# CITY OF ALBUQUERQUE

**Re:** Albuquerque Studios Master Plan Development  
Traffic Impact Study, Memo 4<sup>th</sup> TIS response, received 11/23/2021  
Report date October 13, 2021, HT#R16DA3006A  
Engineer's Stamp 10/13/2021

The subject Memo 4<sup>th</sup> response for the Traffic Impact Study received on October 13, 2021, has been reviewed by the City. The following comments are to be addressed satisfactorily before final approval by the City of Albuquerque Planning Development Transportation Section.

Intersection 9: Eastman/Mesa del Sol Blvd.

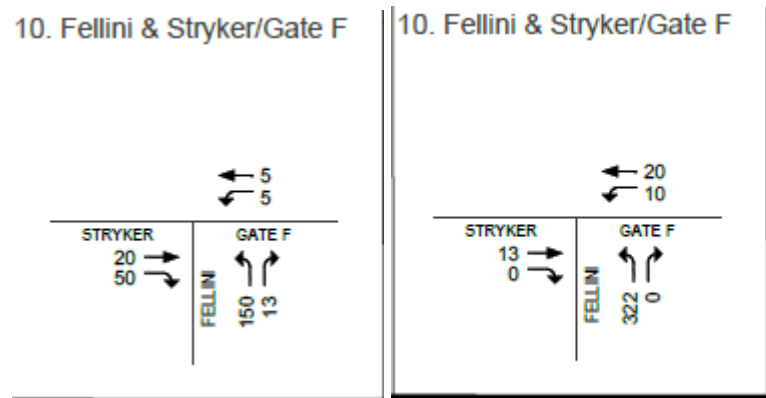
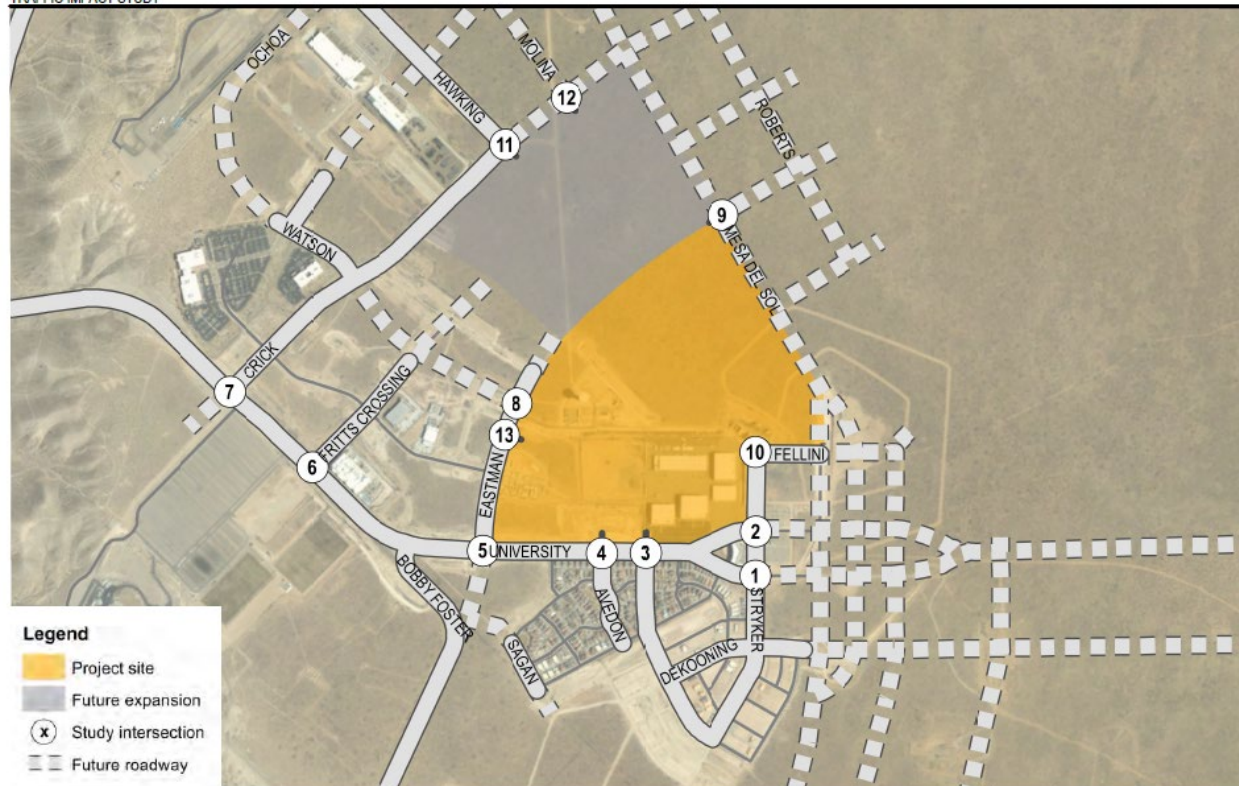
- Intersection 9: Eastman/Mesa del Sol Blvd.
- Mesa del Sol northbound left-turn to be added in the median.
- Intersection 10: Hawkings/Fellini/Stryker
- Stryker eastbound to southbound Fellini; widen Stryker to incorporate a left-turn lane

Intersection 10 Hawking/Fellini/Stryker:

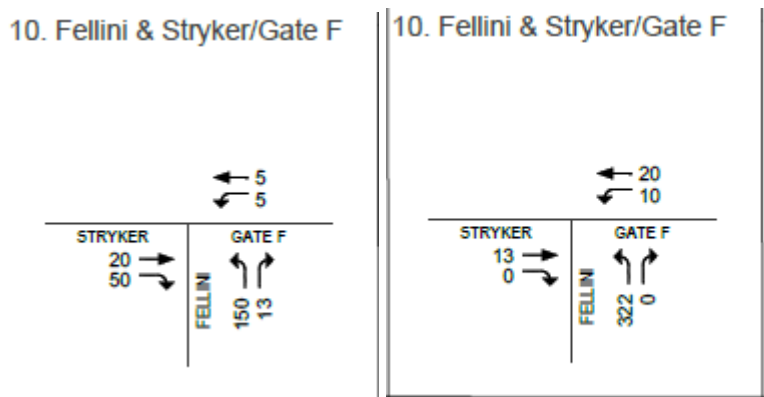
- Fellini northbound to Stryker westbound; Fellini to incorporate a right-turn lane
    - Provide crosssections to show constraints that may need to be resolved to increase the street width as needed.
